Reference No:	2023/62/93567/E
Site Address:	62, Ings Mill Avenue, Clayton West, Huddersfield, HD8 9QG
Description:	Erection of dormer windows and increase in ridge height, replacement access gates and boundary fence and new decking area
Recommending Officer:	Elenya Jackson

DECISION – CONDITIONAL FULL PERMISSION

OFFICER REPORT: 2023/93557

Client Mrs Jackson
 Title Site Plan Proposed
 Sheet Size A3 Drawn DRJ

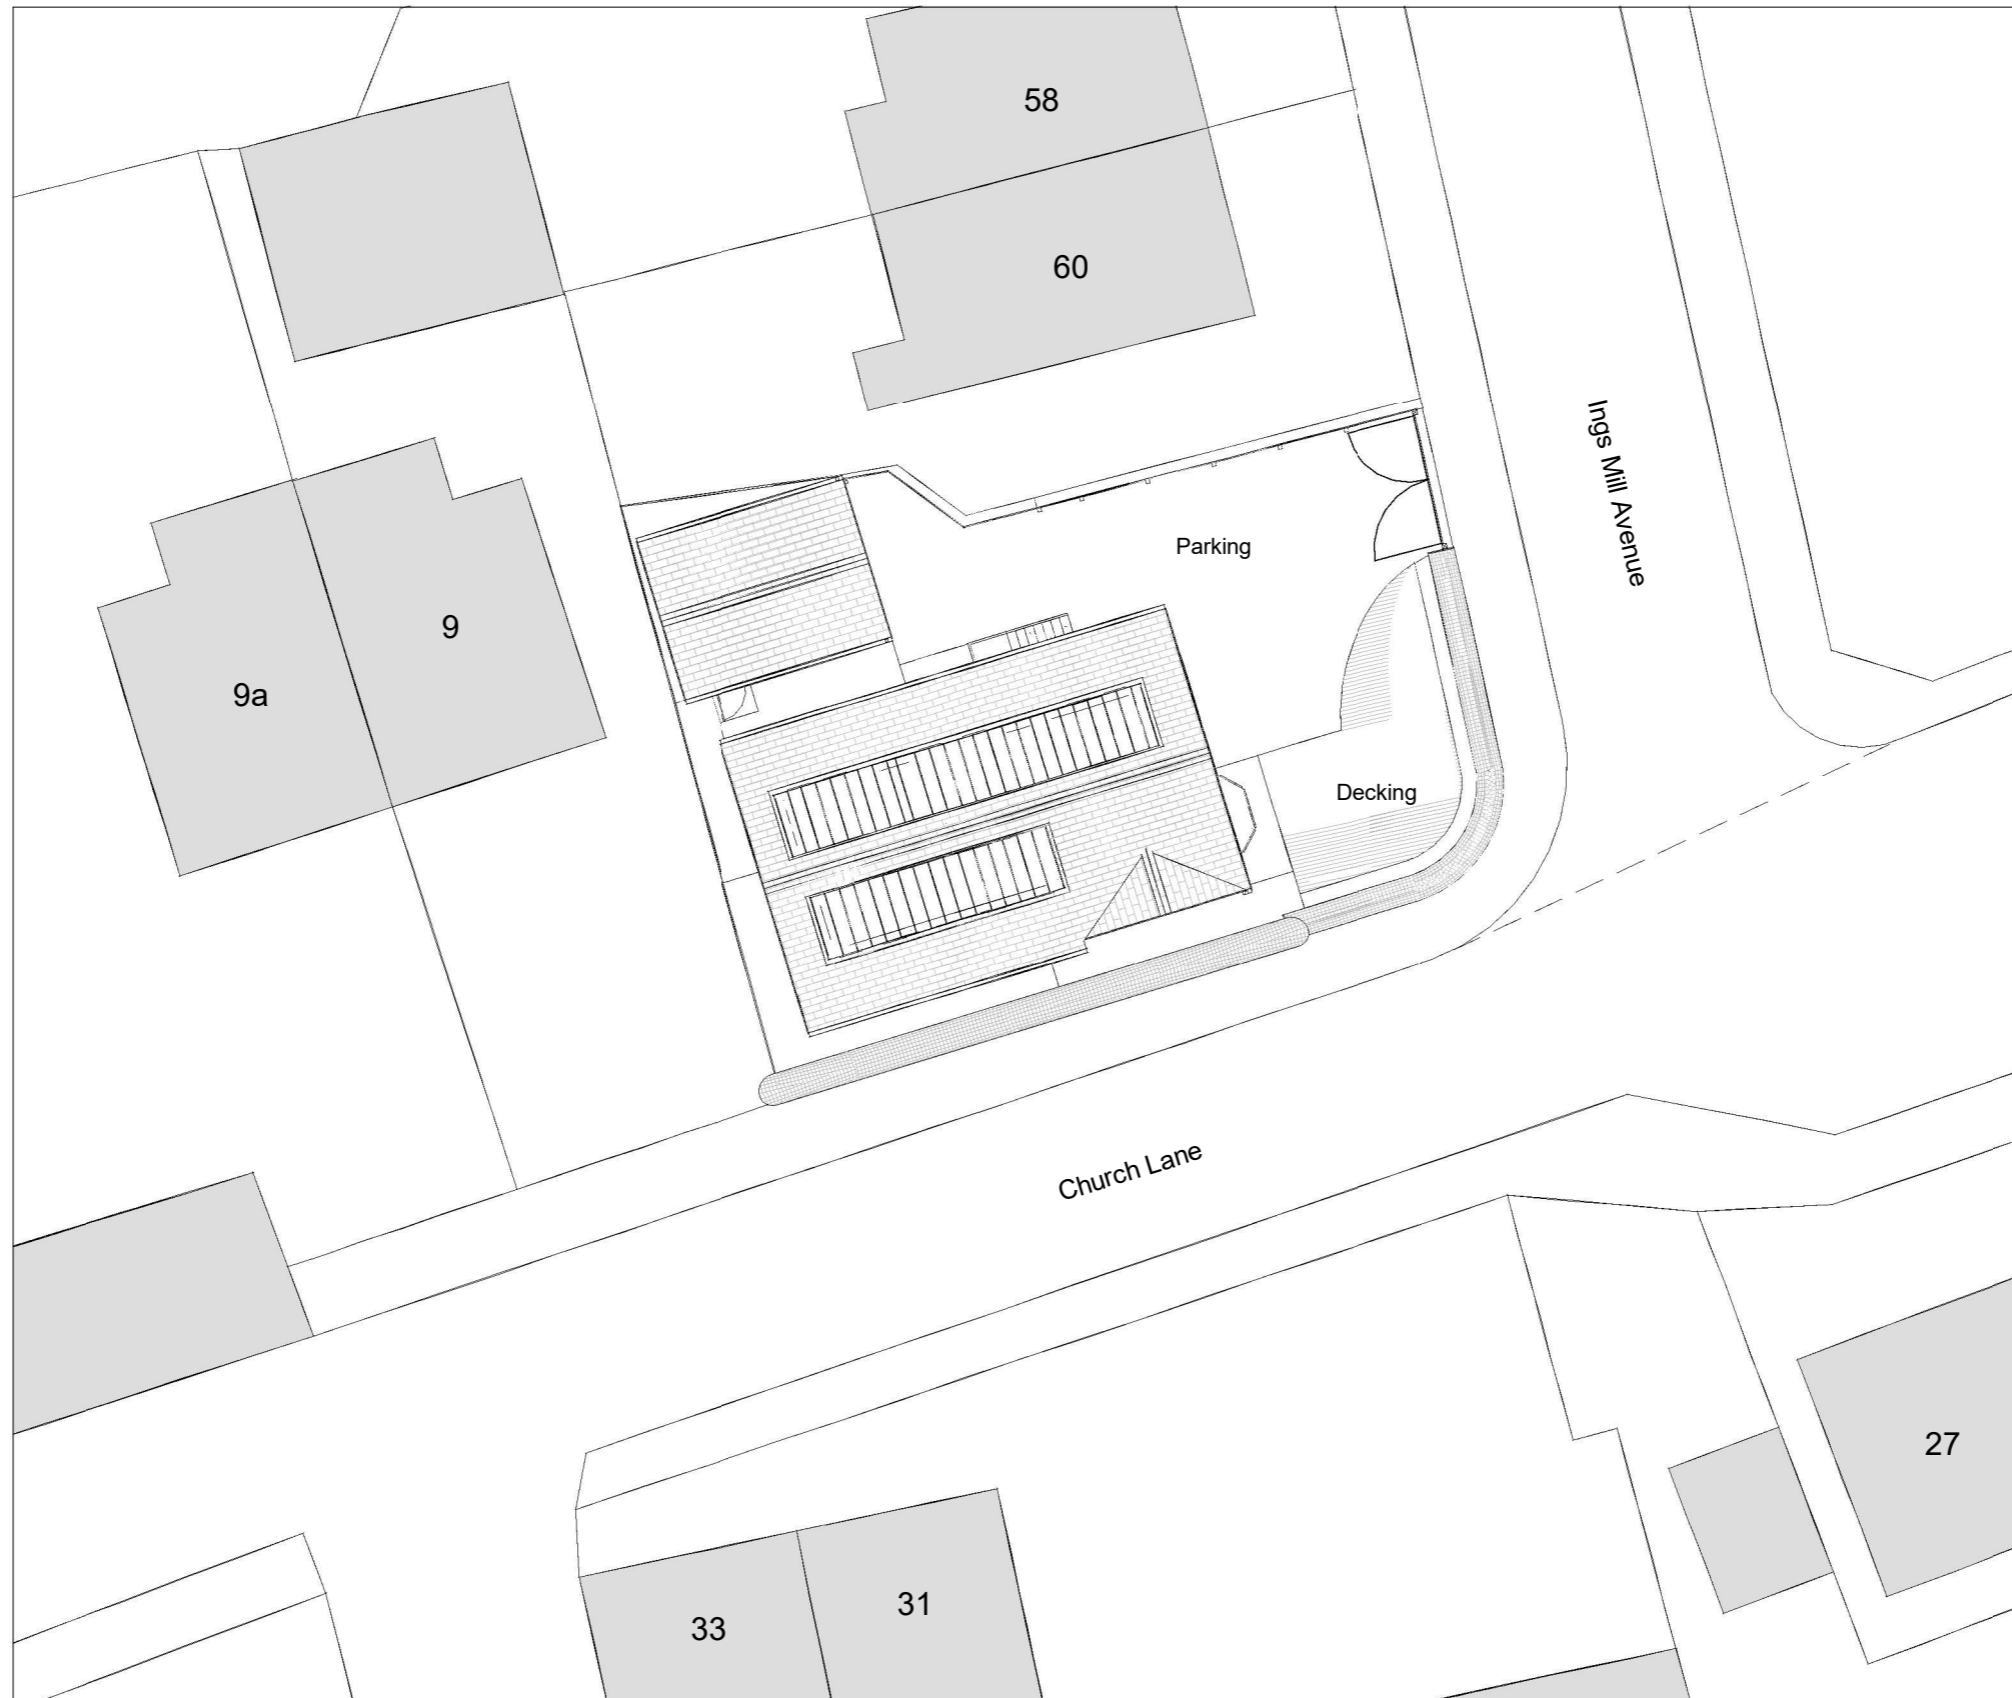
The proposal would introduce 14.9m of fencing along the northern boundary which would be set back 1m from the edge of the highway.

It is considered that the alteration to the fence would not enclose the entire site and the hedgerow would be retained to the east and south of the site. The fence would also be set back from the street scene and would not be out of keeping in this instance.

01-First  
 Floor  
 Proposed  
 Scale 1 : 100

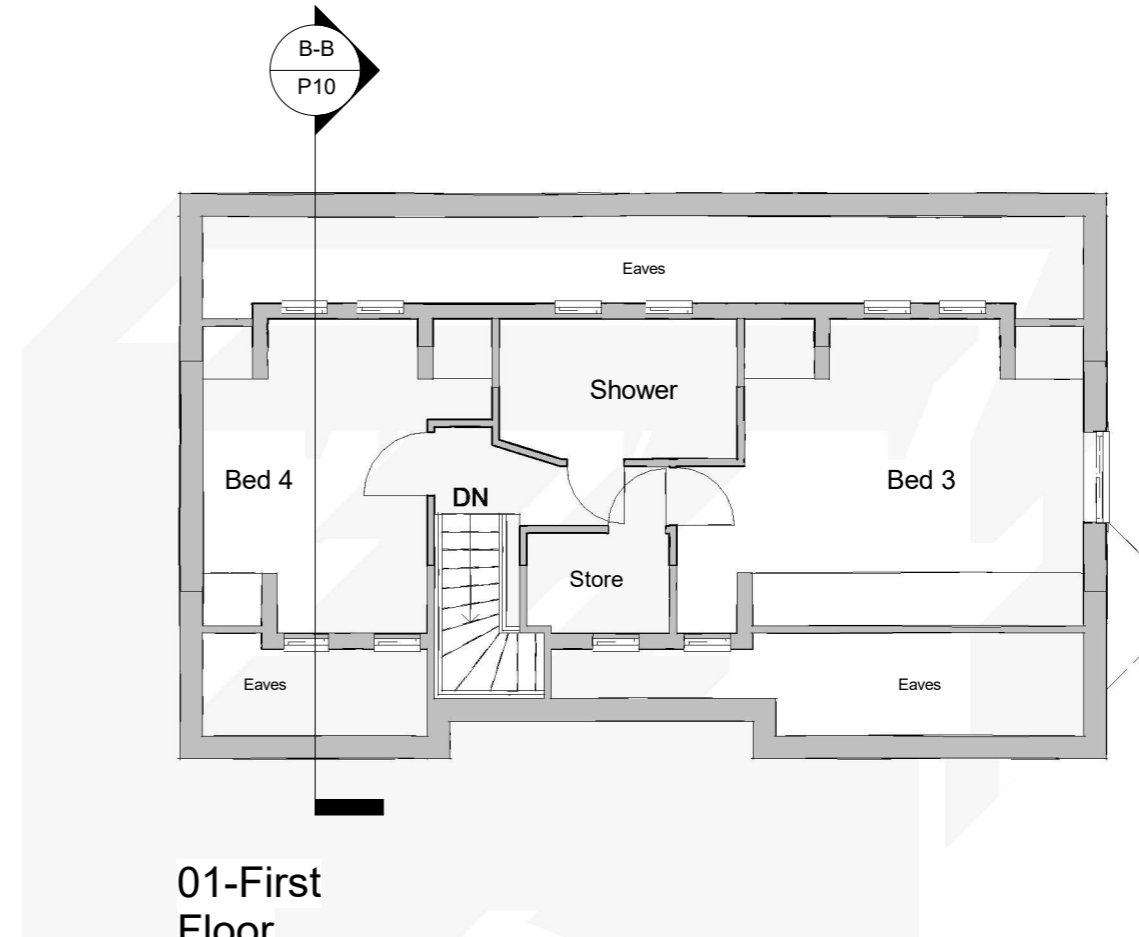
Overlooking: The proposed dormer to the northern elevation would introduce side facing windows which would face the side of no.60 and its amenity space. Four of these windows would relate to bedrooms 3 and 4. It is acknowledged by officers there are currently roof lights in the host dwelling, but the relationship would be altered to a more direct relationship if the windows were changed from roof lights to a dormer. Having reviewed the plans, officers notice that the northern windows for bedroom three would be secondary to a window in the gable end of the dwelling and bedroom four would feature windows in the southern elevation. Therefore, officers consider it necessary to add in an obscured glazing condition to the northern windows to protect the private amenity space of the occupiers of no.60.

5. Notwithstanding the approved plans, all first floor windows in the northern elevation of the dormer hereby approved shall in the first fitting be obscured glazing with a Pilkington level of four or equivalent. This shall be retained for the lifetime of the development.

Section B-B
Proposed
Scale 1 : 50

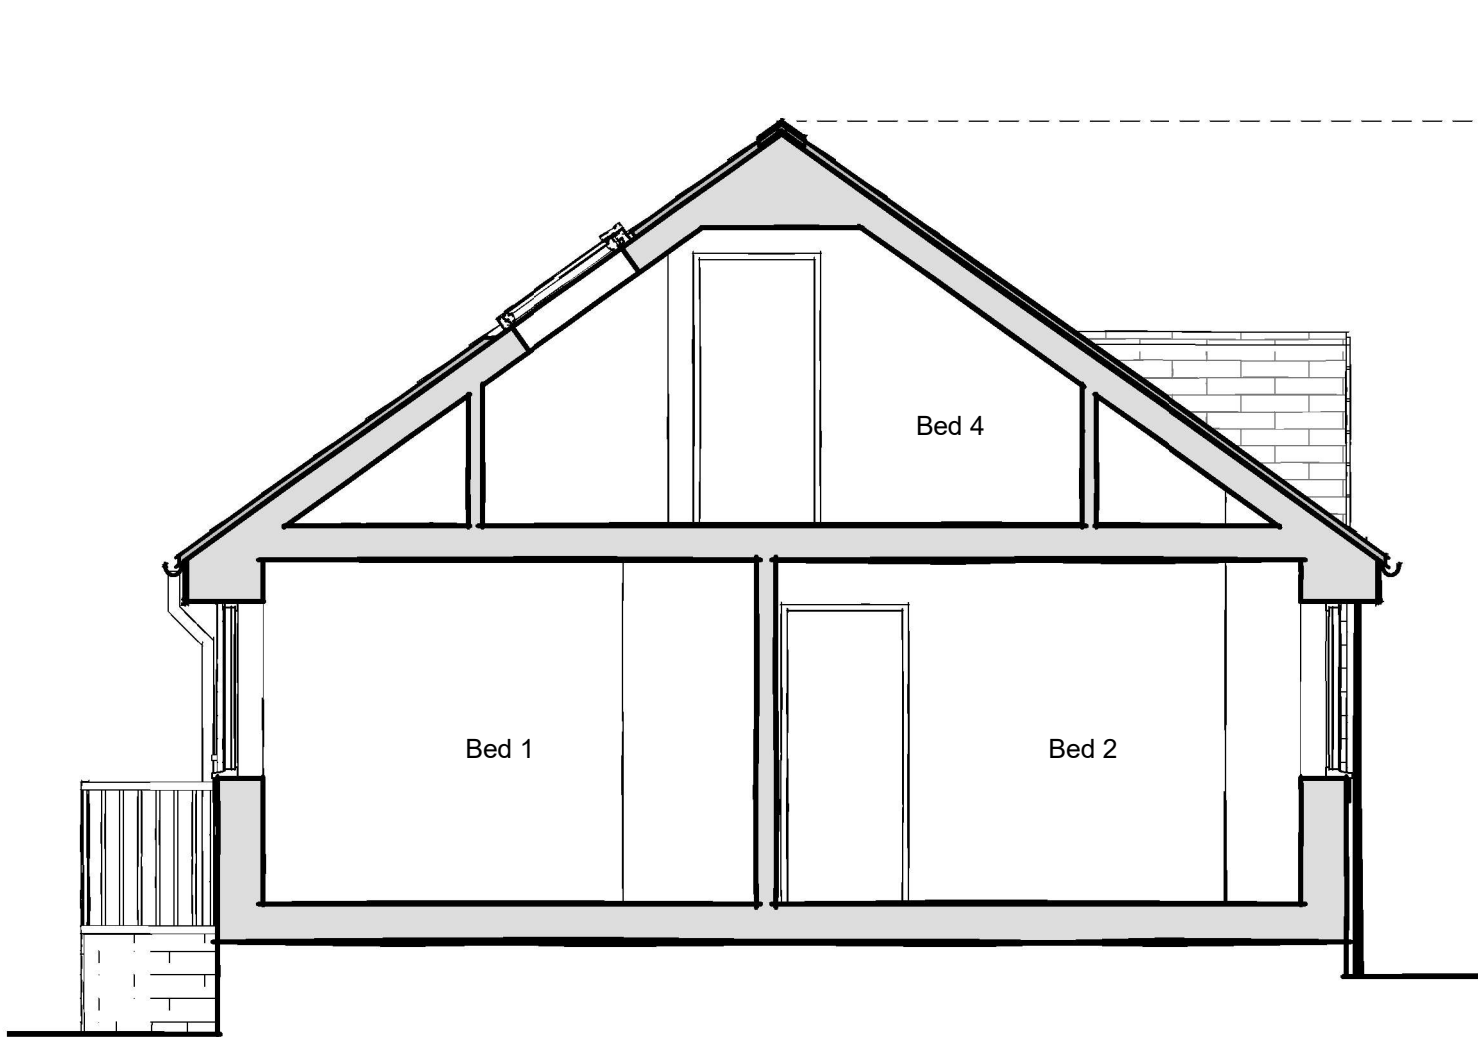
The existing roof is a pitched roof which would be retained if the proposal received planning permission. The existing maximum height of the property is 6.3m and this would be increased to 6.7m.

As previously highlighted, the dwellings that make up the street scene are not uniform in appearance. The majority feature side facing gable ends however, there is one other property of similar design. It is considered that the increase to the roof height of the dwelling would be marginal in the context of the dwelling and would retain the existing roof pitch.

Client Mrs Jackson  
Title Site Elevations Proposed  
Sheet Size A3 Drawn DRJ

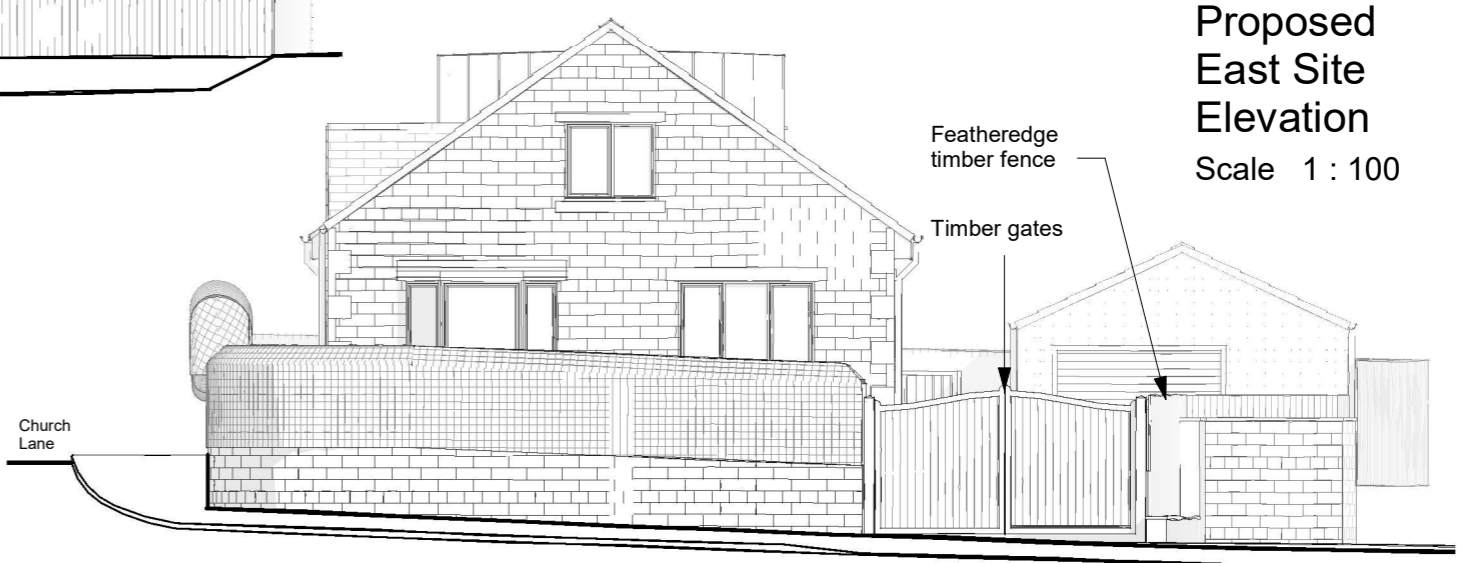
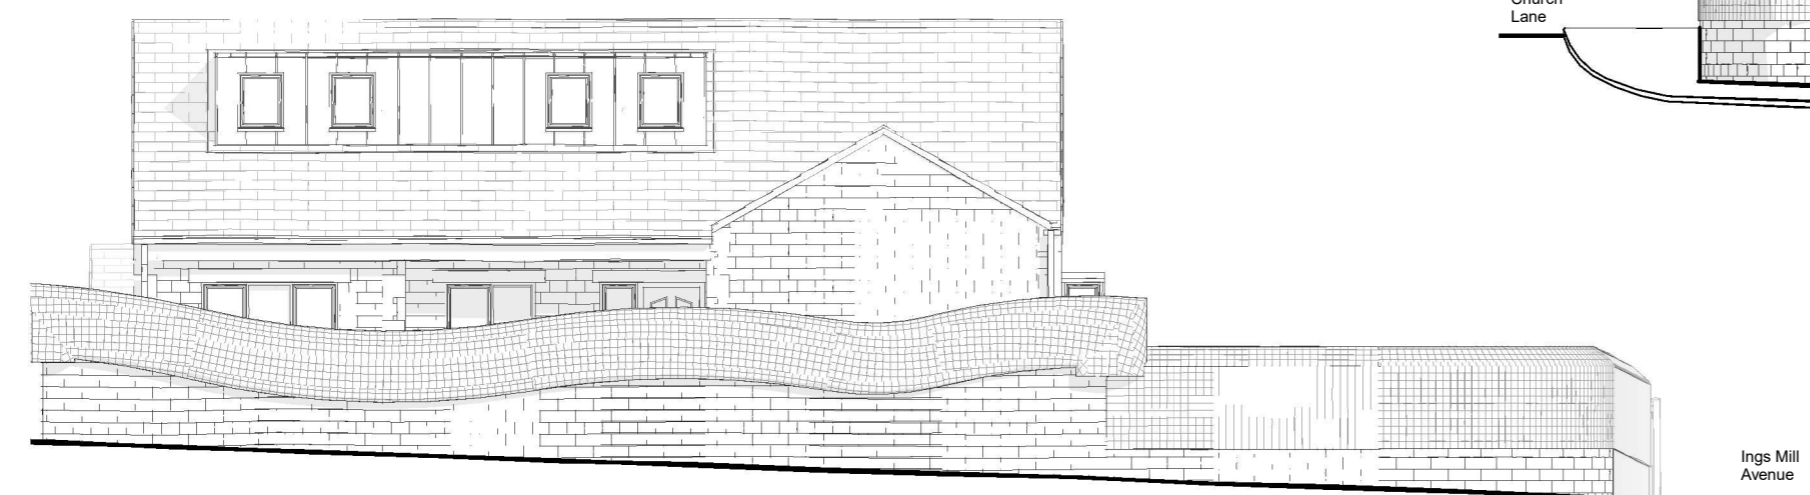
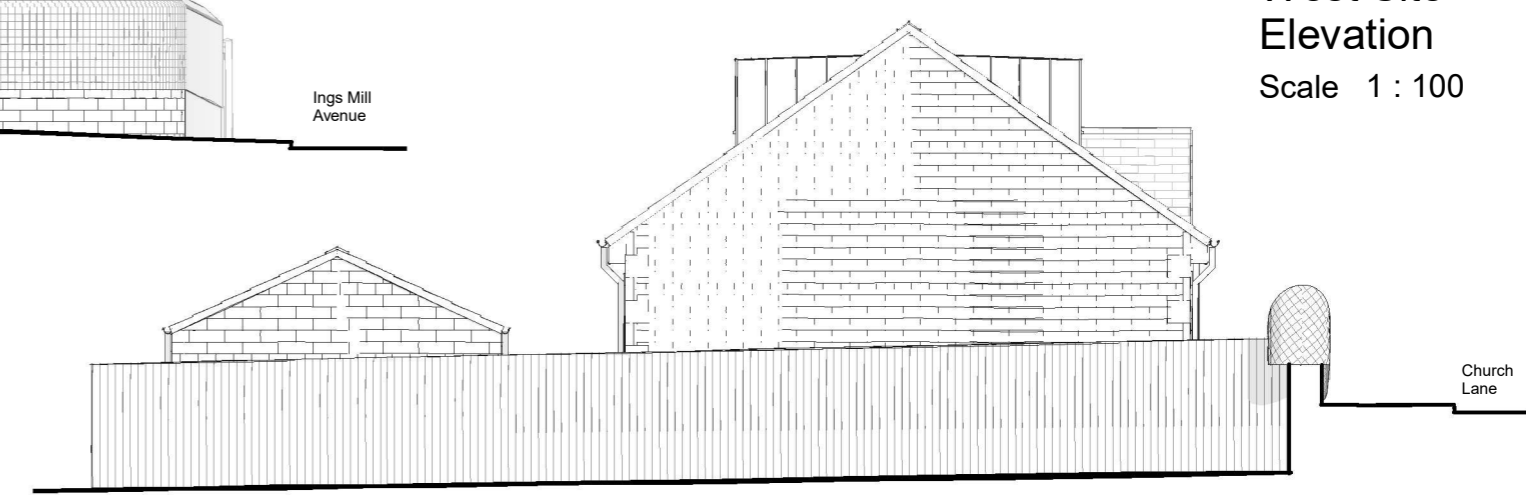
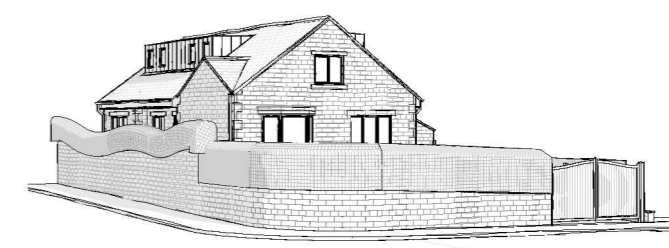
Kirklees Development Management Charter together with the National Planning Policy Framework and the DMPO 2015 encourages negotiation/engagement between Local Planning Authorities and agents/applicants, this is only within the scope of the application under consideration. Officers requested alterations to the boundary treatments on site due to concerns raised by KC Highways.

The proposals would result in the intensification of the domestic use of the site.. The site currently has a driveway and the proposal would not result in the loss of any parking spaces onsite. KC Highways were informally consulted on the application and requested that the boundary treatment was reduced in height for a depth of 1m from the highway. It is considered that due to no spaces being lost as a result of the proposal and the receipt of amended plans for the boundary treatment, the proposal is considered to comply with Policy LP22 of the Kirklees Local Plan along with Key Design Principles 15 & 16 of the House Extensions & Alterations SPD.

Revised boundary treatment plans were requested.
